CITY OF ALBUQUERQUE

April 17, 2023

Re: Luna Leaf Grow Facility
2017 Ridgecrest Dr. SE
30-Day Temporary Certificate of Occupancy
Transportation Development Final Inspection
Architect's Stamp dated 05-16-22 (L17-D003)
Certification dated 03-29-23

PARKING SIGNAGE REQUIREMENTS  
N.T.S.

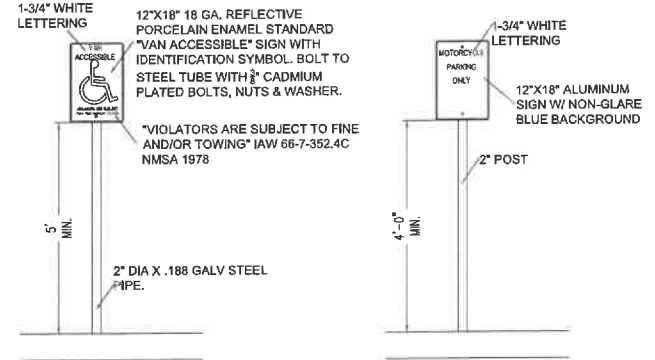
1. Please provide ADA sign. The ADA accessible parking sign must have the required language per 66-7-352.4C NMSA 1978 **"Violators Are Subject to a Fine and/or Towing."** Please call out detail and location of signs.
- Parking lot striping should be done only in white.
